OXFORDSHIRE COUNTY COUNCIL'S RESPONSE TO CONSULTATION ON THE FOLLOWING DEVELOPMENT PROPOSAL

Application no: 21/03177/F

Proposal: Full planning application for employment development (Use Classes E(g)(iii), B2 and/or B8) and associated parking and servicing, landscaping and associated works

Location: Axis J9 Phase 3 Howes Lane Bicester

Drawing Title:
CYCLE SHELTER DETAILS

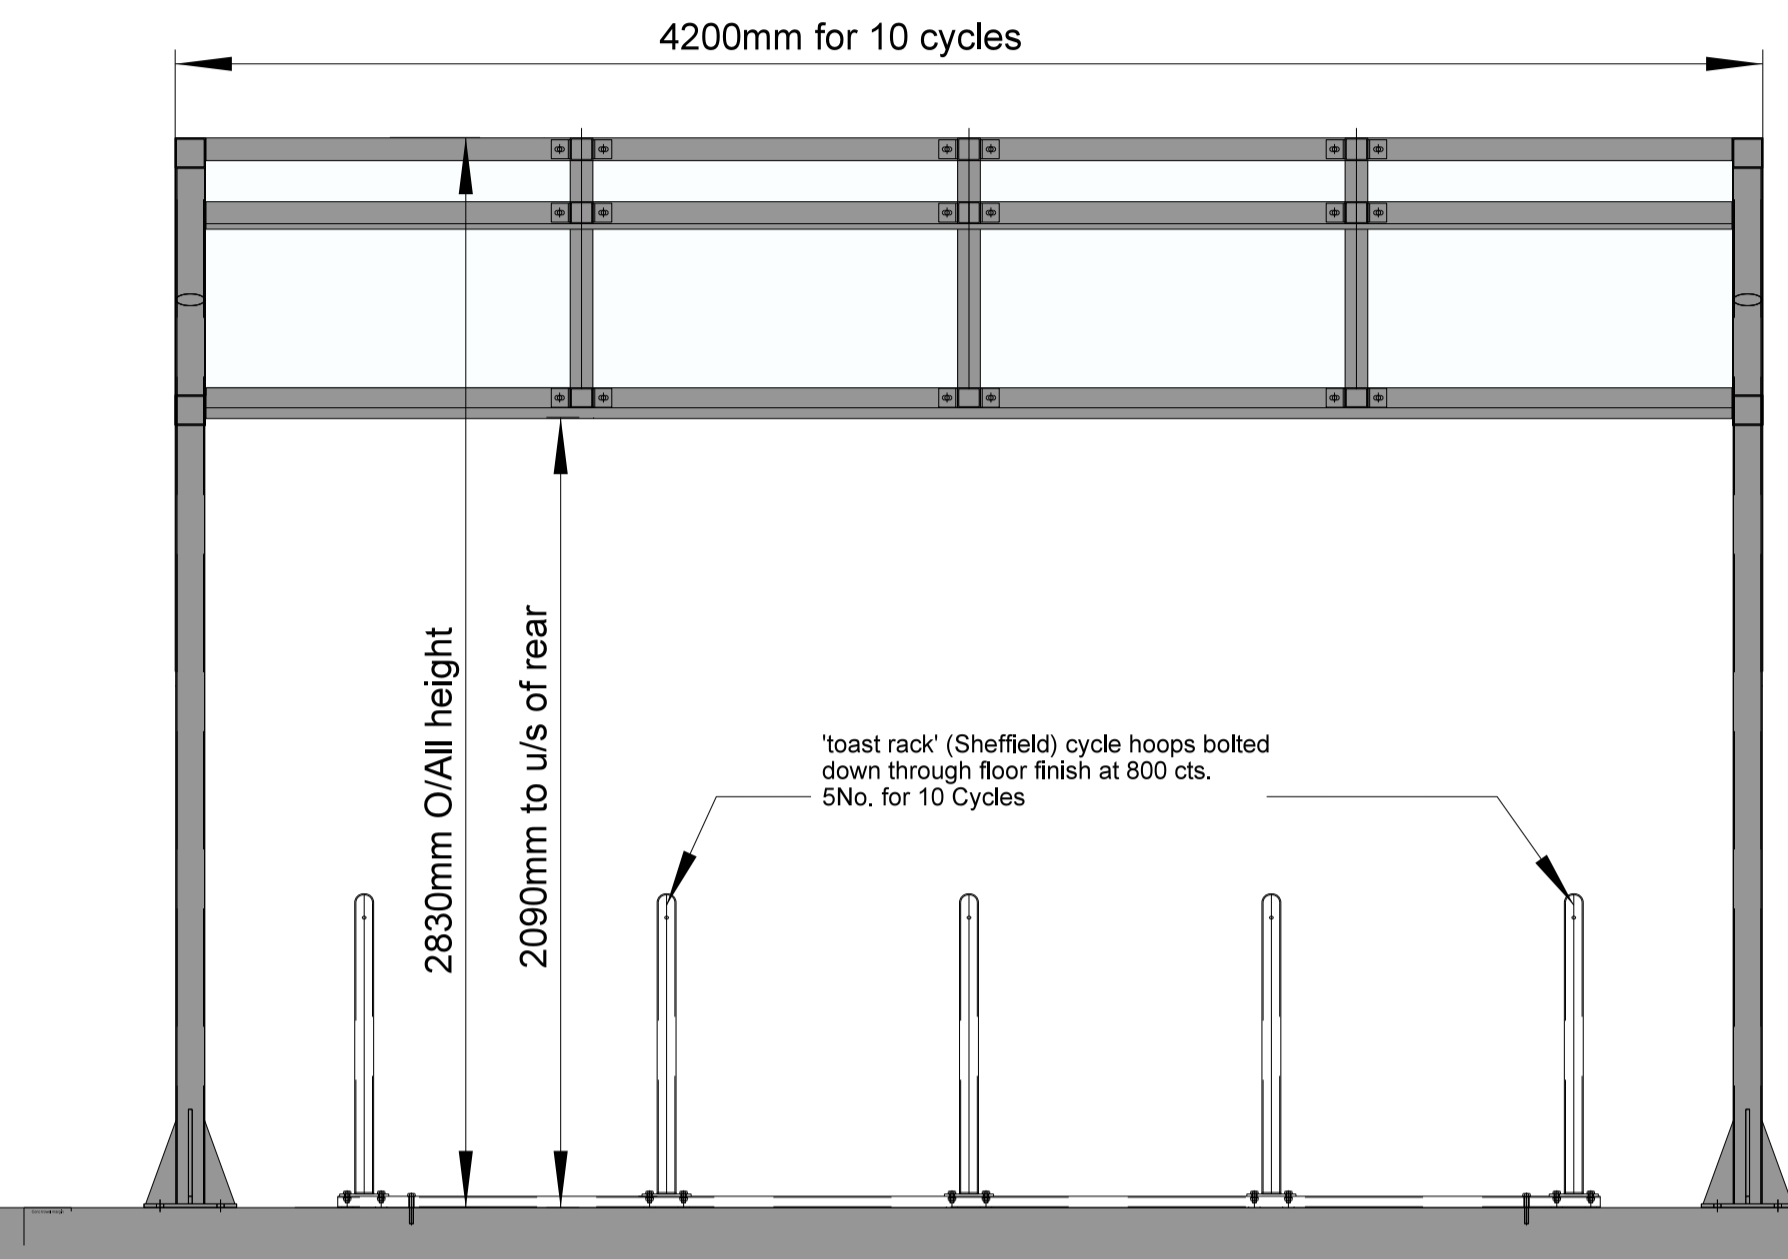
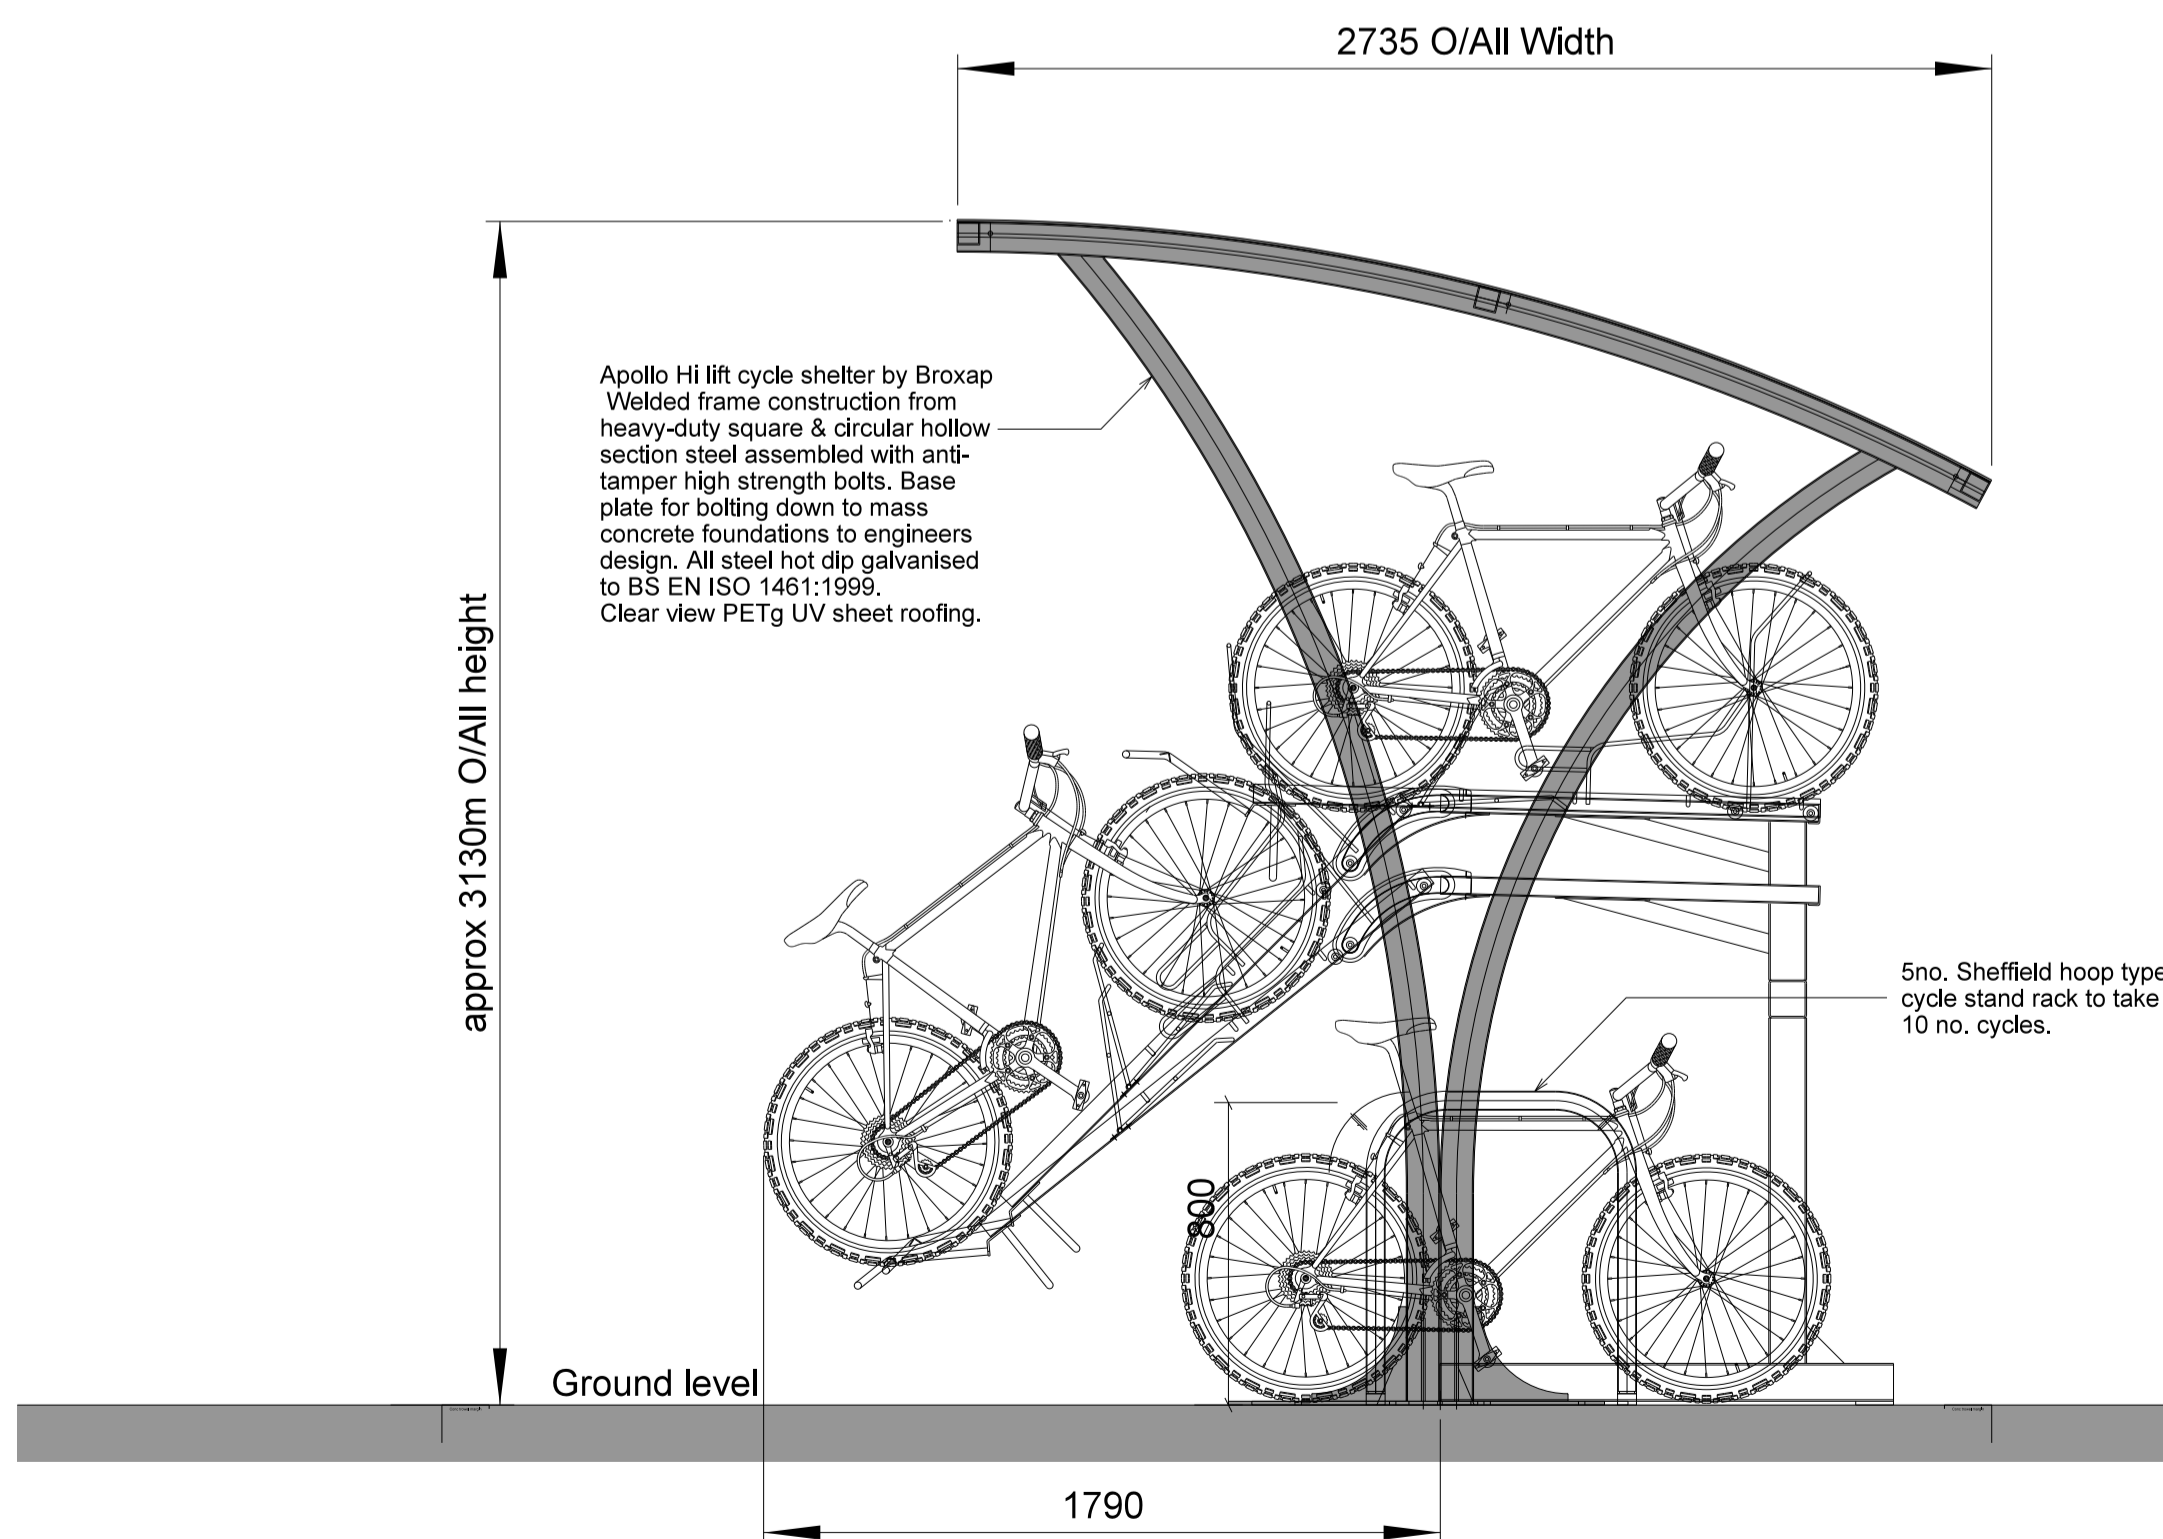
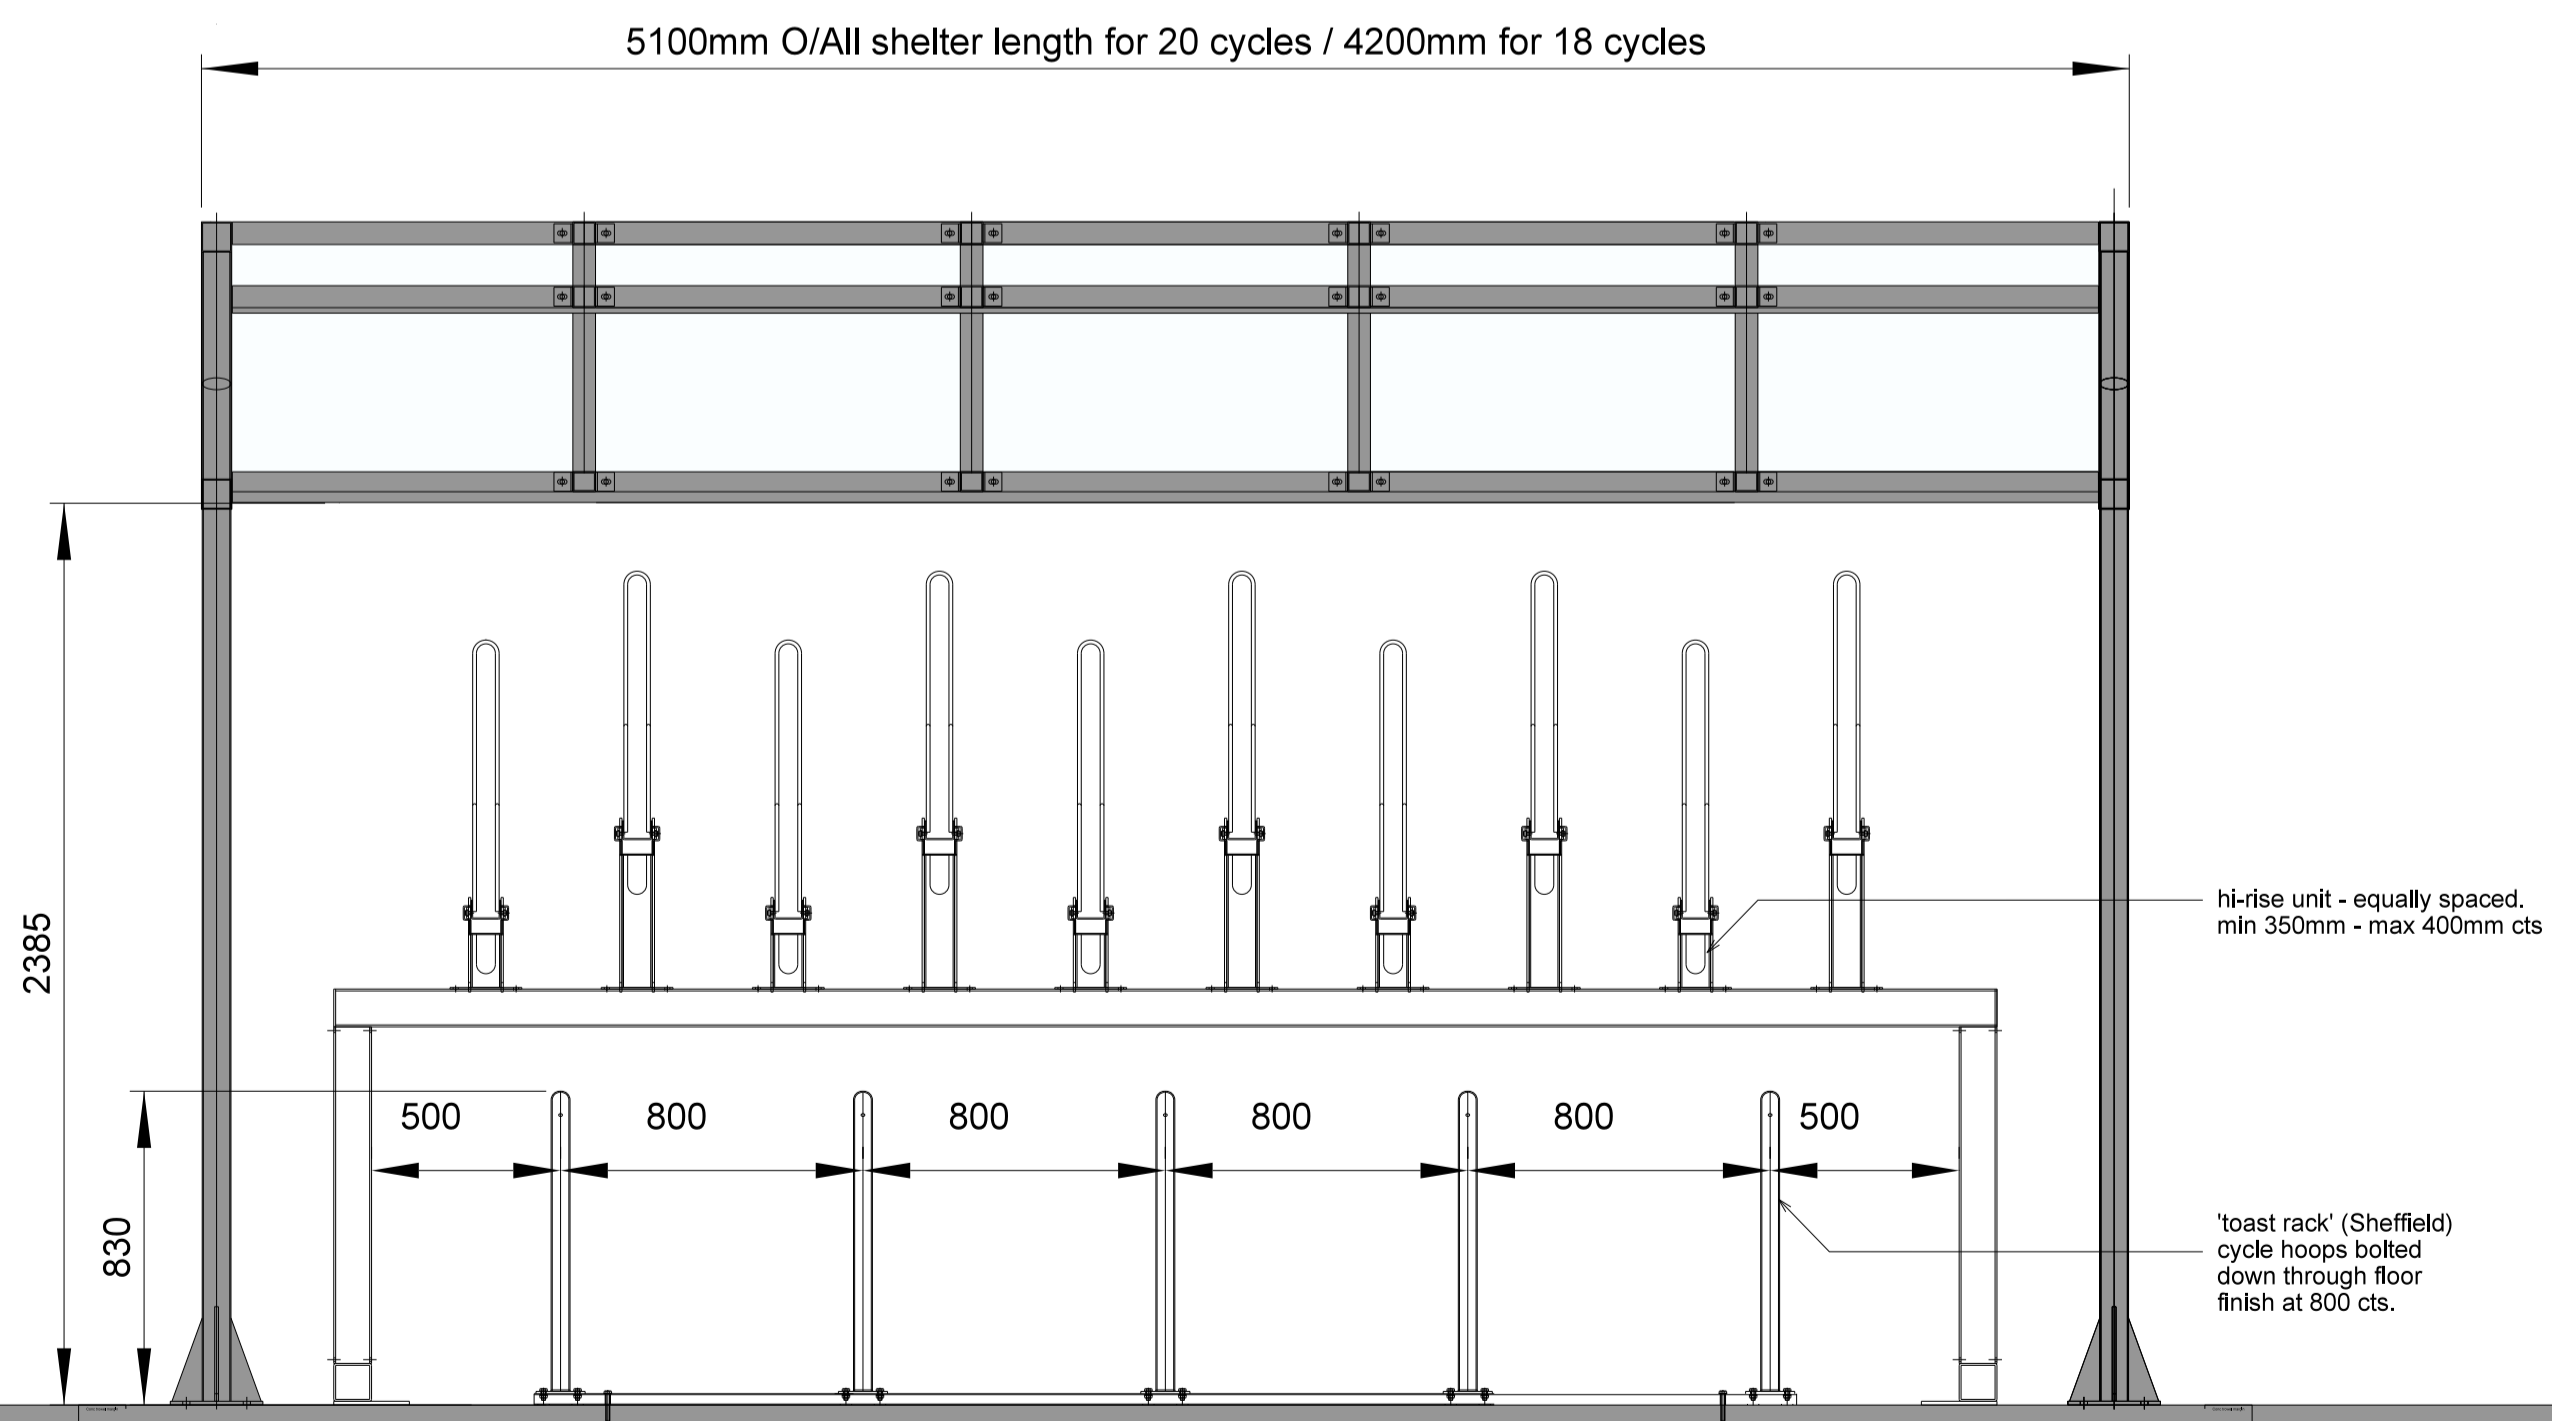
I can now see there are seven shelters which appear to accommodate 5 stands (10 cycles) each, which would be an acceptable level of cycle parking. However, some of

these shelters are still distant from the main entrances of the buildings and should be nearer than most car parking spaces, to prioritise cycling over car travel to the site, and in the interest of security. Some are still shown within the goods vehicle manoeuvring areas, which is unacceptable from the point of view of safety and convenience.
